Recommendation Report for Works to Tree(s) on trees subject to a Tree Preservation Order (

REF NO: FP/227/14/T

LOCATION: The Green
The Ridgeway
Felpham Beach Estate Felpham

PROPOSAL: Surgery to various trees

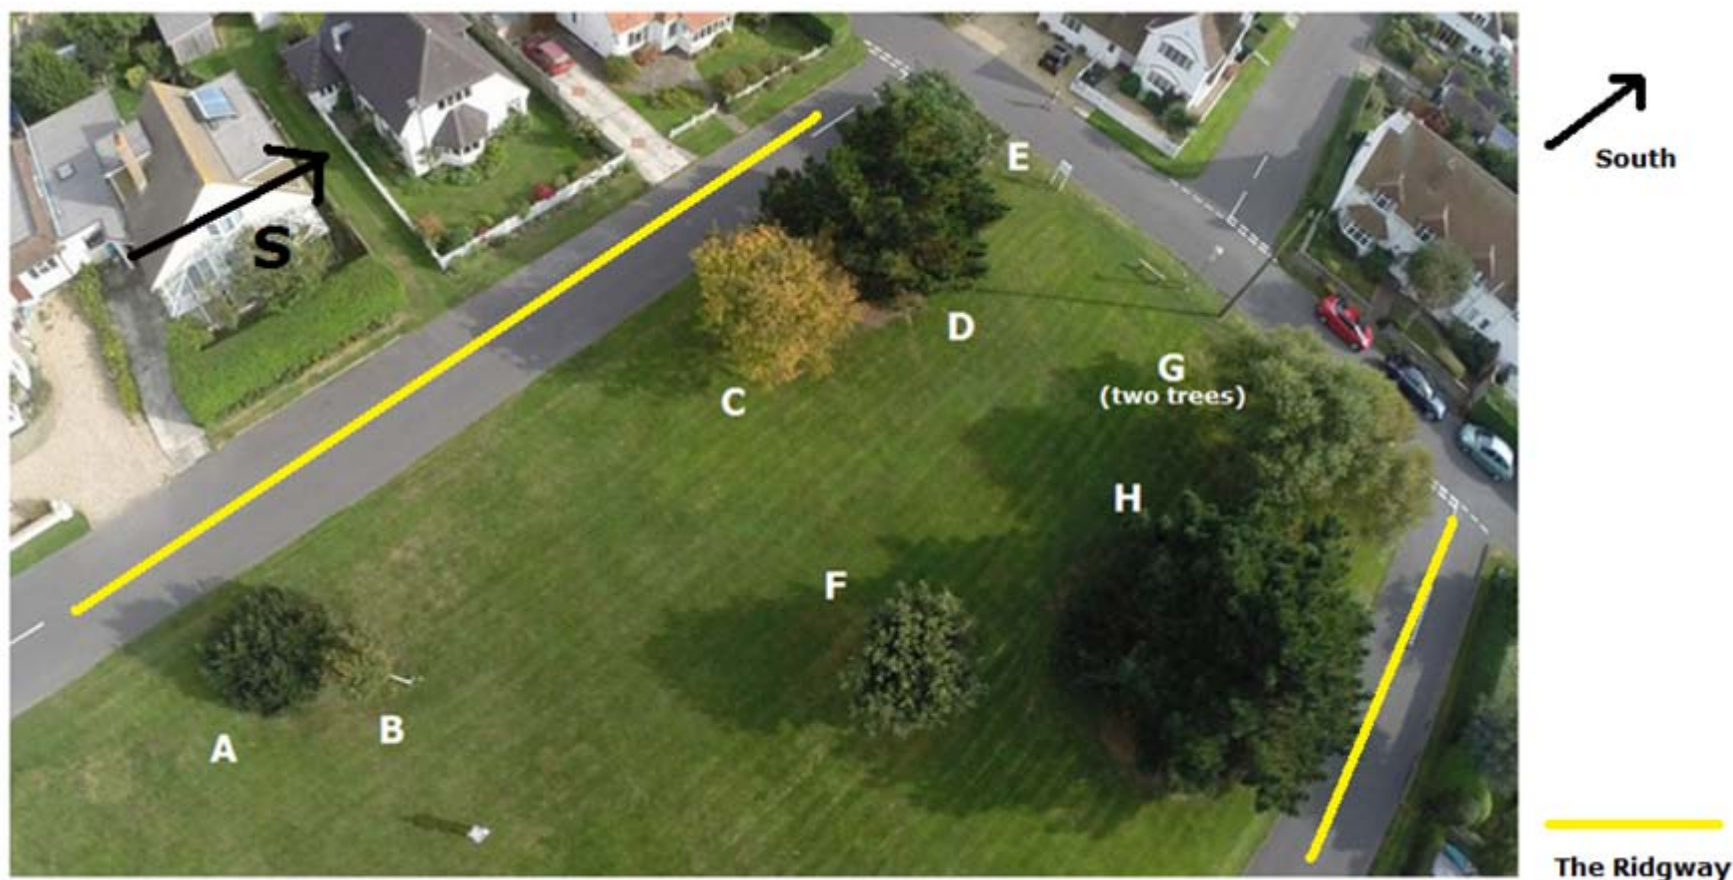
·The applicant has requested the removal of the lowest east facing branch at 1.5 meters height form T1. Competition of this pruning operation is unlikely to have any overall effect on T1's longevity and/or form, as removal this lowest branch is likely to rebalance this individual. Also noted on the site inspection was the extensive abiotic damage that has been sustained to the Basal area (most likely causes of this abiotic damage is conflict with mowers/trimmer's). This tree is not covered by an active TPO order.

·For T2, the applicant has requested to reduce the tree by 1.2 meters and remove a branch overhanging the road. From the site inspection it is clear that this tree has particular poor form, as it the main stem has lent over in an eastern direction. As for the 'branch to be removed over the road', the site inspection did not reveal a specific branch that spanned over the road. Moreover, the requested reduction of 1.2 meters will alleviate any potential conflict with highway users. This tree does have evidence of previous pruning (possibly a reduction). Also T2 is subject to TPO order.

·For T3, the applicant has requested to reduce the tree by 1.2 meters and remove a branch overhanging the road. From the site inspection, it is apparent that T3 is in a much better form than T2, but does have less presence in the wider landscape. Again for the 'branch to be removed over the road', the site inspection identified a number of individual limbs that would meet that profile. It is also clear the requested reduction of 1.2 meters will alleviate any potential conflict with highway users. This tree does have evidence of previous pruning (possibly a reduction). Also T3 is subject to TPO order.

·For T4, the applicant has requested to fell this individual. It is clear from the site inspection that this tree has poor form, as the main stem has a heavy lean to the north east at about 2 meters height. It was also apparent that a large amount of the crown mass appears to be dead (over 70%). It is also apparent that there is interference between T4 and T5, which is causing suppression (especially T4). T4 is currently not covered by a TPO order.

·For T5, the applicant has requested to reduce the tree by 1.2 meters. This tree does have a lean to the north (due to the prevailing wind). The proposed reduction of 1.2 meters will remove the end weight from the canopy, which considering T5's lean is likely to increase the retention span of T5. Also T5 is subject to TPO order.

·For T6, the applicant has requested to crown lift the tree by 2 meters. This action is unlikely to be a detriment to the aesthetic value and/or longevity of T6. This tree is not covered by an active TPO order.

·For T7, the applicant has requested to crown lift the tree by 2 meters and reduce the lateral spread by 2 meters. The lateral spread is beginning to encroach the main highway, the desired reduction will alleviate this interference. Also T7 is subject to TPO order.

·For T8, the applicant has requested reduce the lateral spread by 2 meters of the roadside only. The lateral spread of T8 is beginning to encroach the main highway; the desired reduction will alleviate this interference. Also T8 is subject to TPO order.

·For T9, the applicant has requested to remove a branch spanning of the roadside. This branch is beginning to encroach the main highway; the desired reduction will alleviate this interference. Also T9 is subject to TPO order.

·For T1, I would have no objection to the proposed operation. No conditions to be set, as this tree has not got an active TPO.

·For T2, I would have no objection to the proposed operation of reduce the tree by 1.2 meters and remove a branch overhanging the road only. The following conditions are to be adhered to;

·For T3, I would have no objection to the proposed operation of reduce the tree by 1.2 meters and remove a branch overhanging the road only. The following conditions are to be adhered to;

·For T4, I would have no objection to the applicants request to fell T4. No conditions to be set, as this tree has not got an active TPO.

·For T5 I would have no objection to the proposed operation of reduce the tree by 1.2 meters only. The following conditions are to be adhered to;

·For T6 I would have no objection to the proposed operation of a crown lift of 2 meters. No conditions to be set, as this tree has not got an active TPO.

·For T7 I would have no objection to the proposed operation of crown raising T7 by 2 meters, and to reduce the tree by 2 meters only. The following conditions are to be adhered to;

·For T8 I would have no objection to the proposed operation of reduce the lateral spread spanning towards the highway, by 2 meters only. The following conditions are to be adhered to;

·For T9 I would have no objection to the proposed operation of reduce the lateral branch spread spanning towards the highway only. The following conditions are to be adhered to;
